WINSOME FILING NO. 3 CULVERT CONSTRUCTION DOCUMENTS

WINSOME FILING NO. 3
EL PASO COUNTY, COLORADO
CONSTRUCTION DOCUMENTS
COVER SHEET

Culvert CDs_v2 redlines.pdf Markup Summary

WINSOME FILING NO. 3
EL PASO COUNTY, COLORADO
CONSTRUCTION DOCUMENTS
CULVERT 1-PLAN & PROFILE

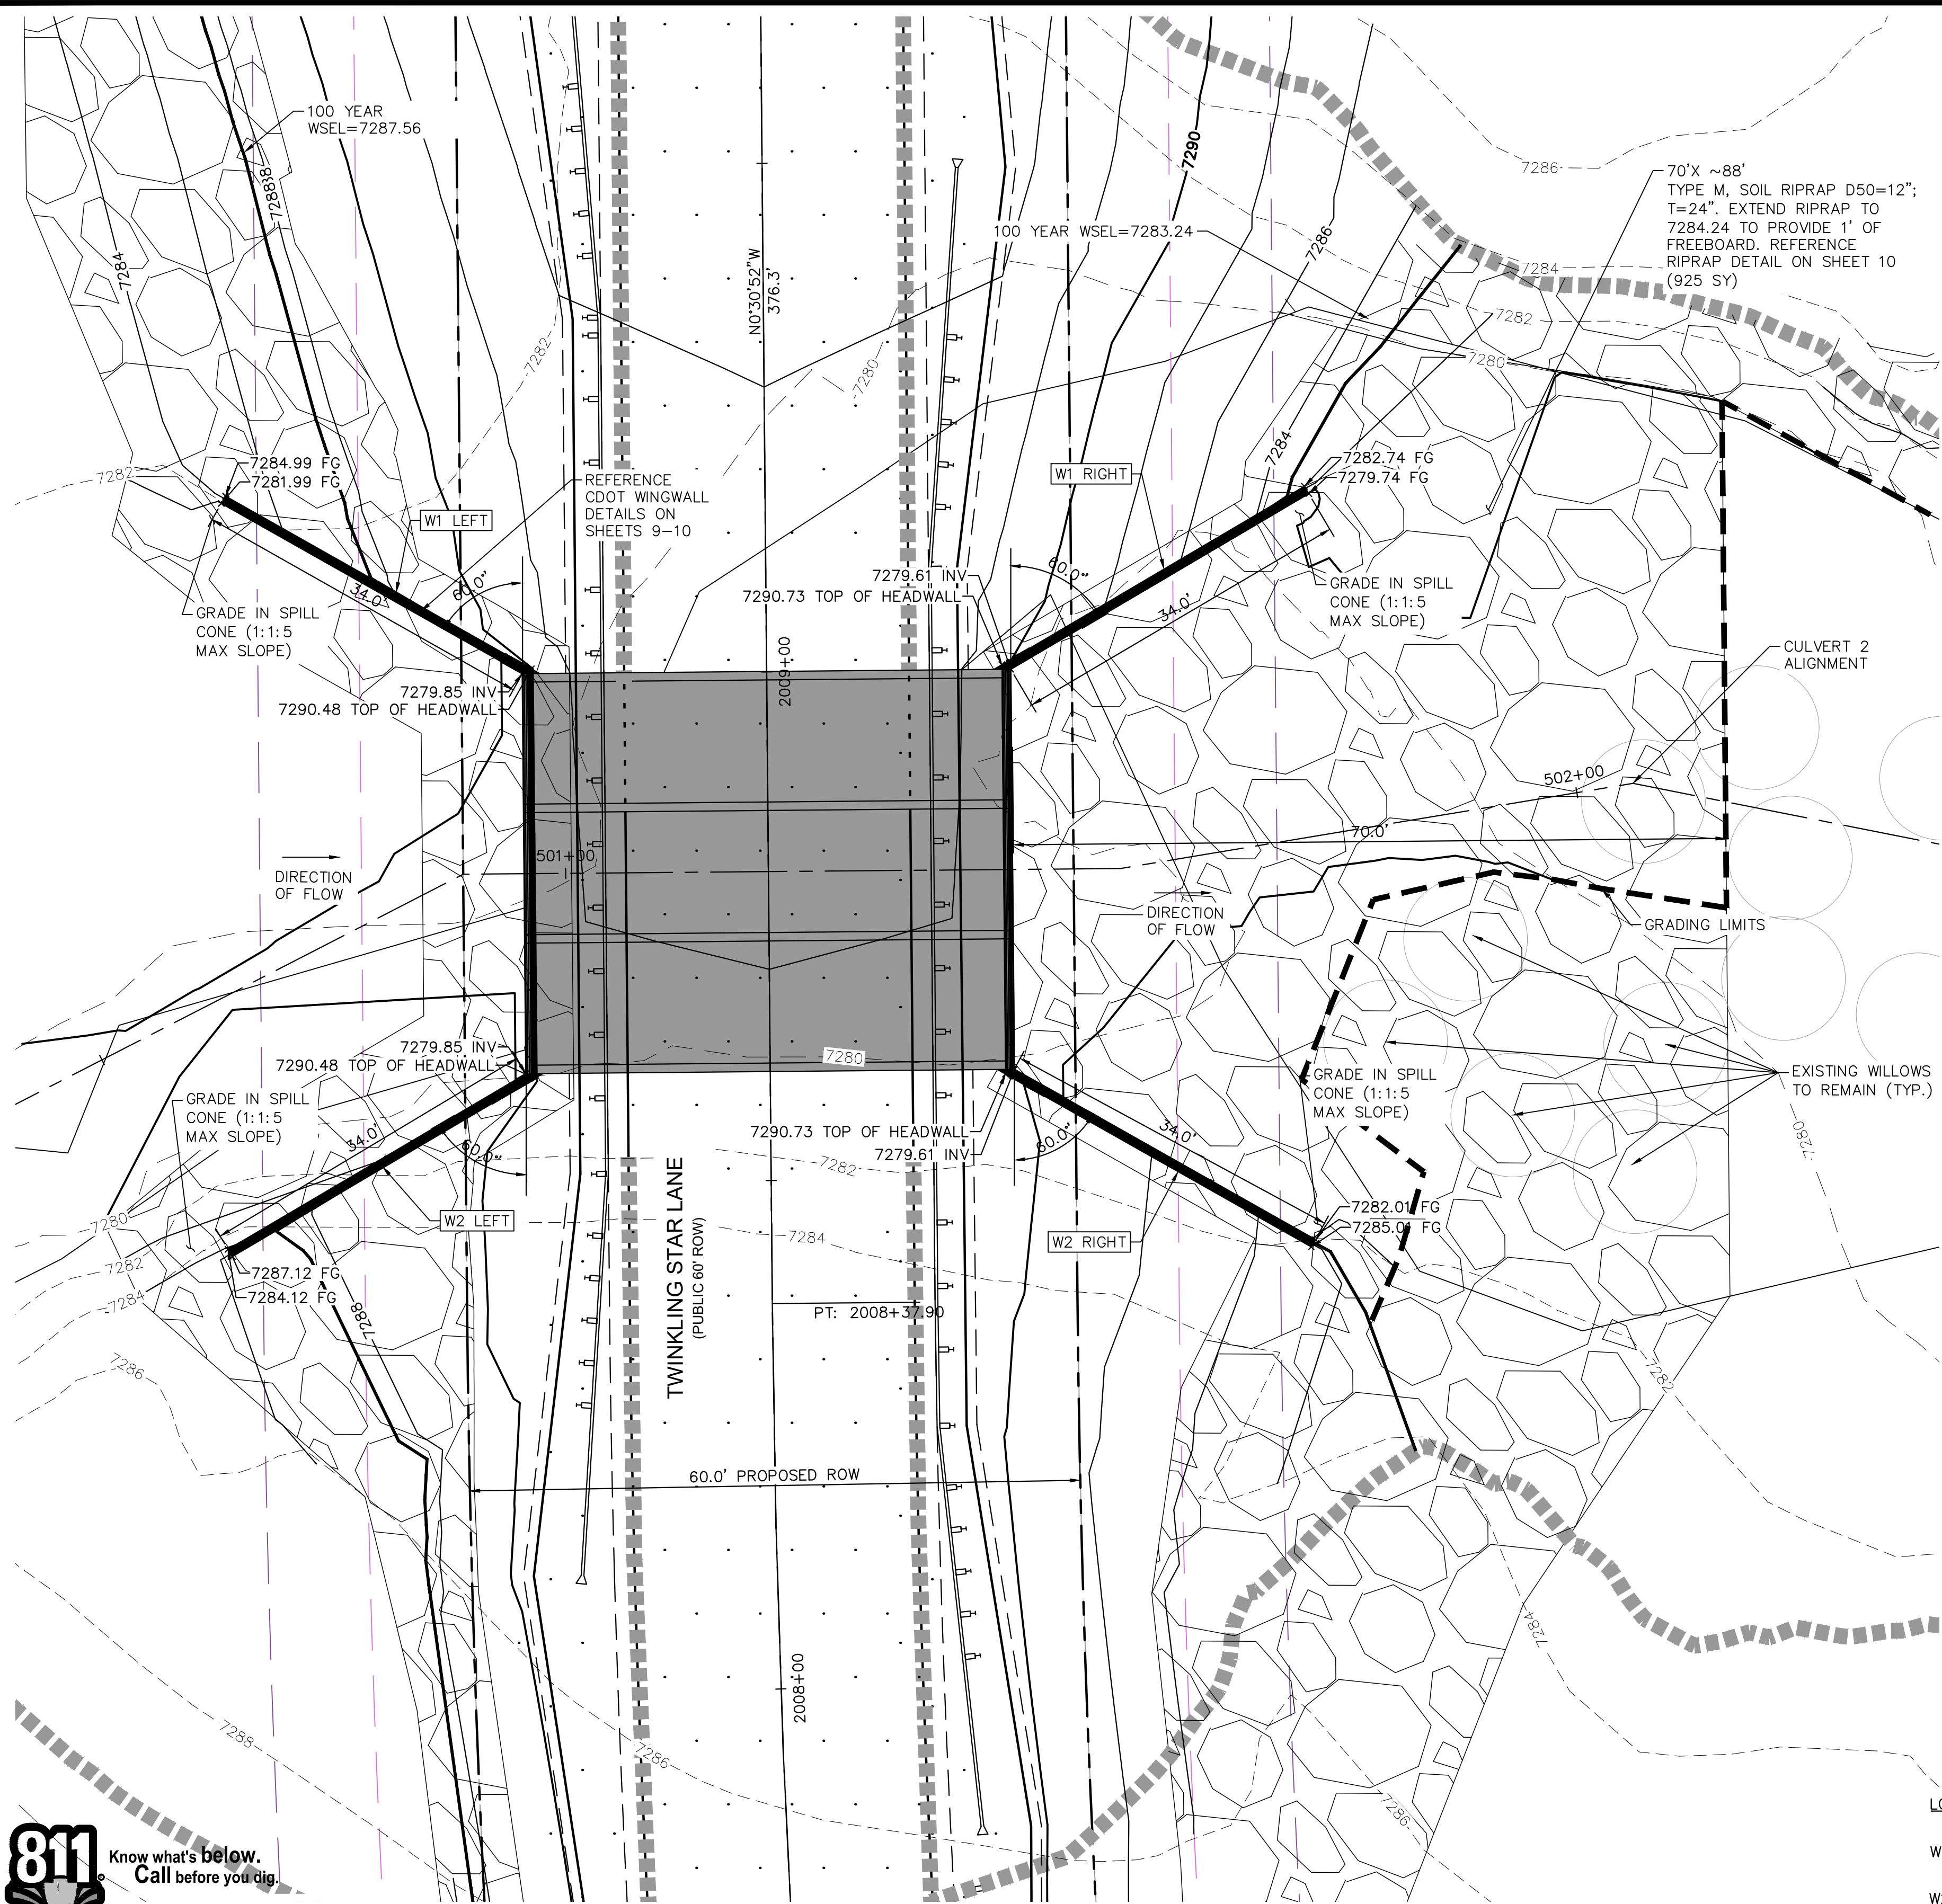
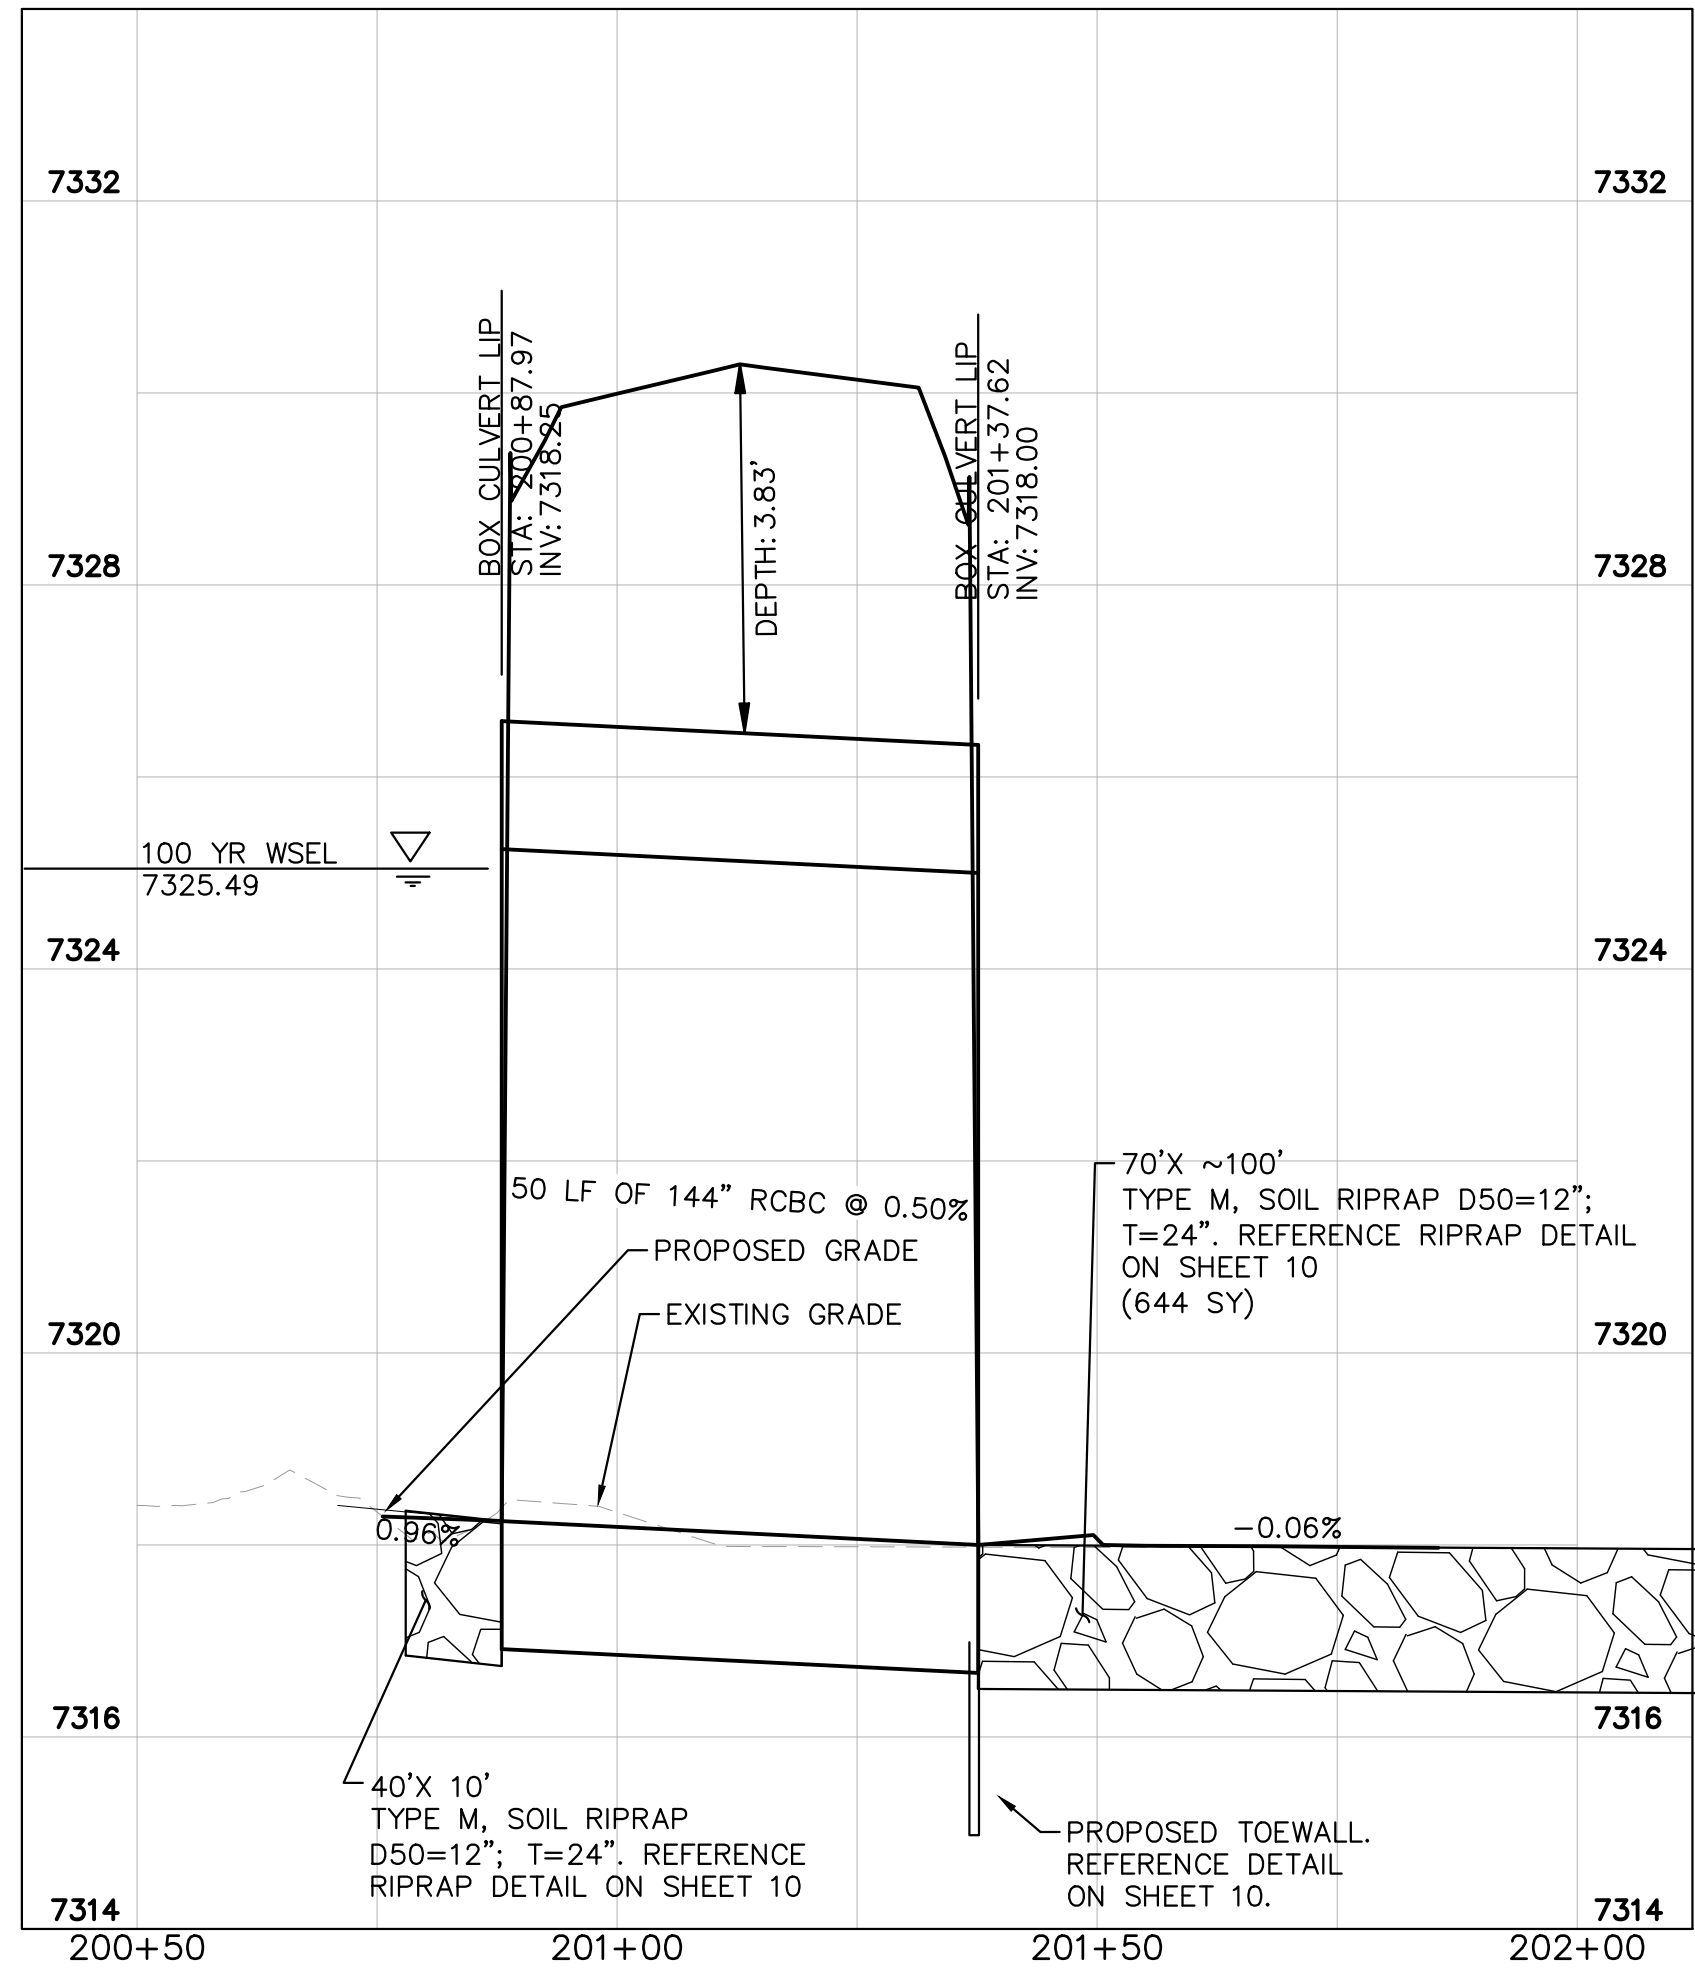
based on the contour it appears the wingwall needs to be extended.
Update all wingwall lengths.

Unresolved. Fix contours or extend retaining wall.
The space between the contour lines indicated near vertical finished ground.

SPILL CONE IS
NOW GRADED
IN

WINSOME FILING NO. 3
EL PASO COUNTY, COLORADO
CONSTRUCTION DOCUMENTS
CULVERT 2-PLAN & PROFILE

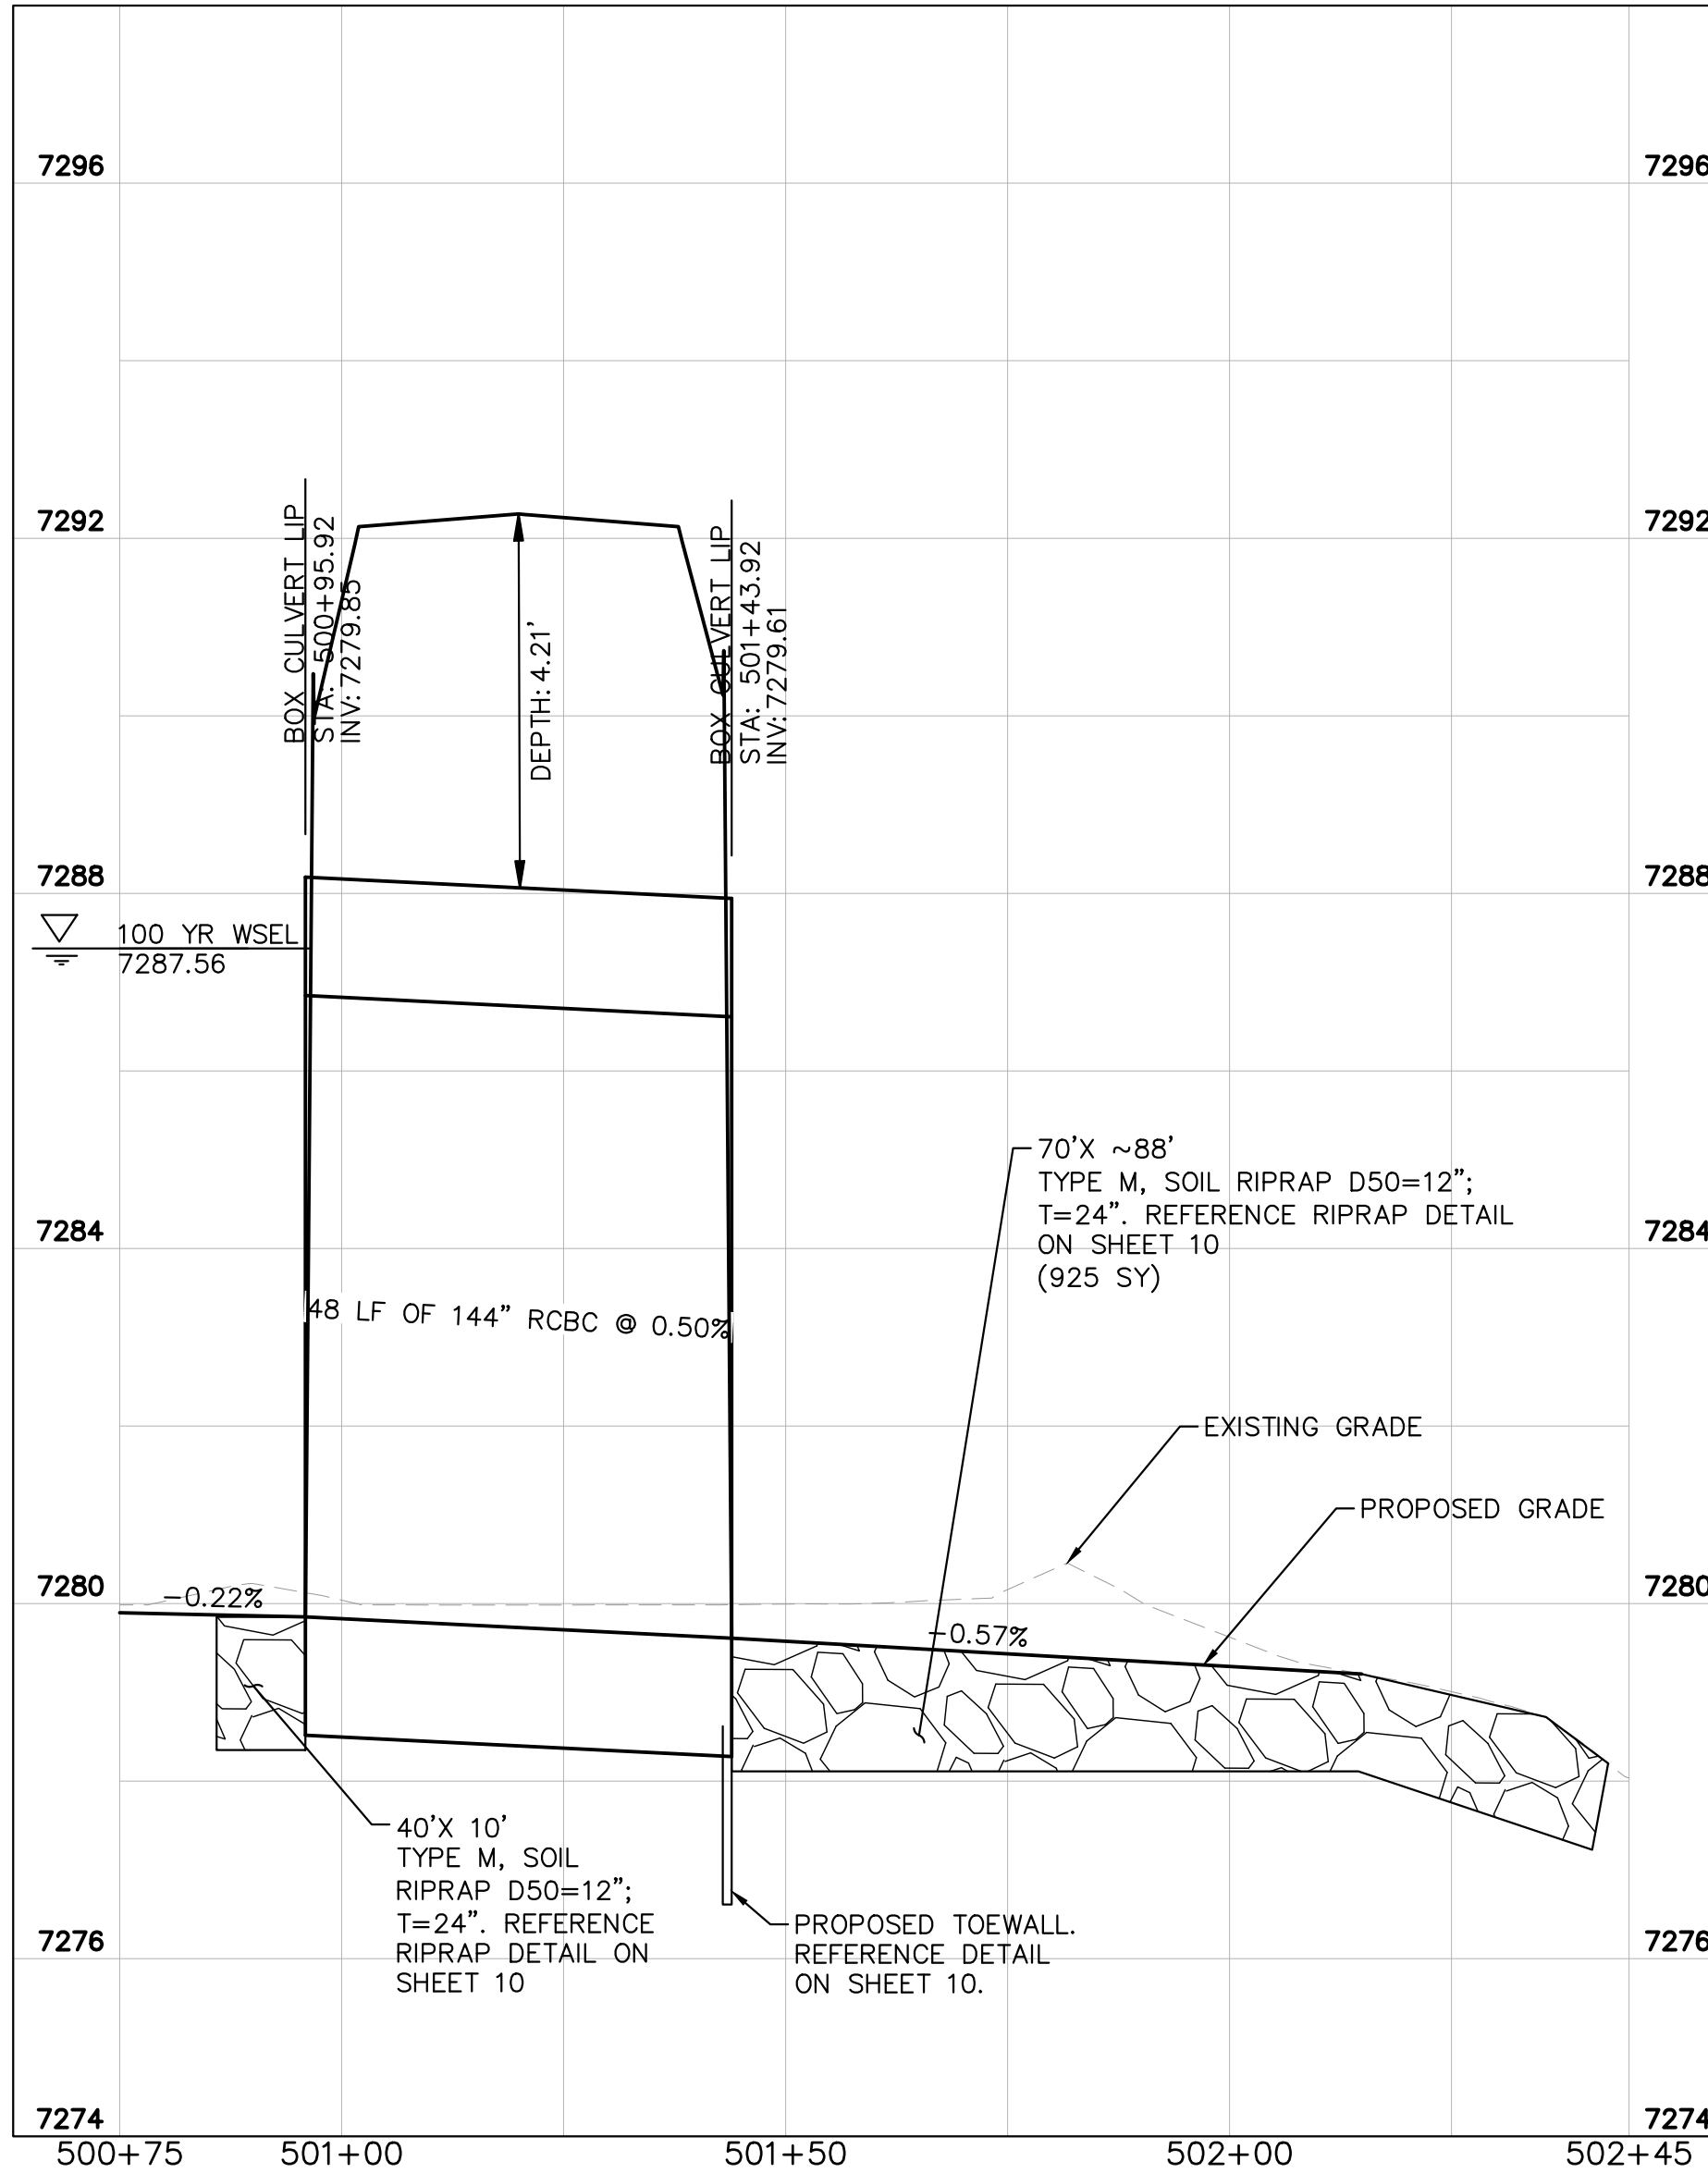
see comment on previous page regarding FG elevations.

SPILL CONE IS NOW GRADED IN
